Celtic Cultural Festival, TU-22-5

Please accept the following comments from El Paso County Public Health for the temporary use request referenced above:

Sheet:
Sht-1
Site Overview

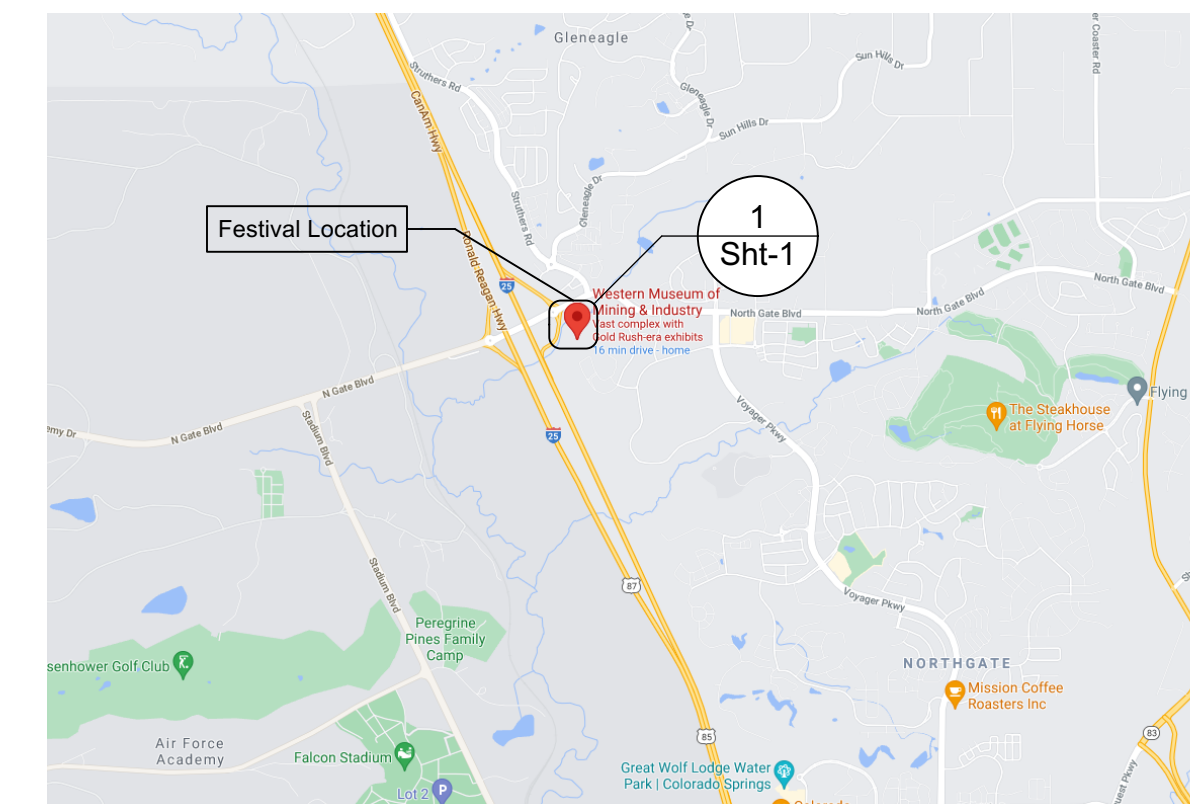
- **Locate your onsite wastewater treatment system, soil treatment area, and do not allow vehicle parking or driving over the area to help prevent damage and premature failure of the system.**
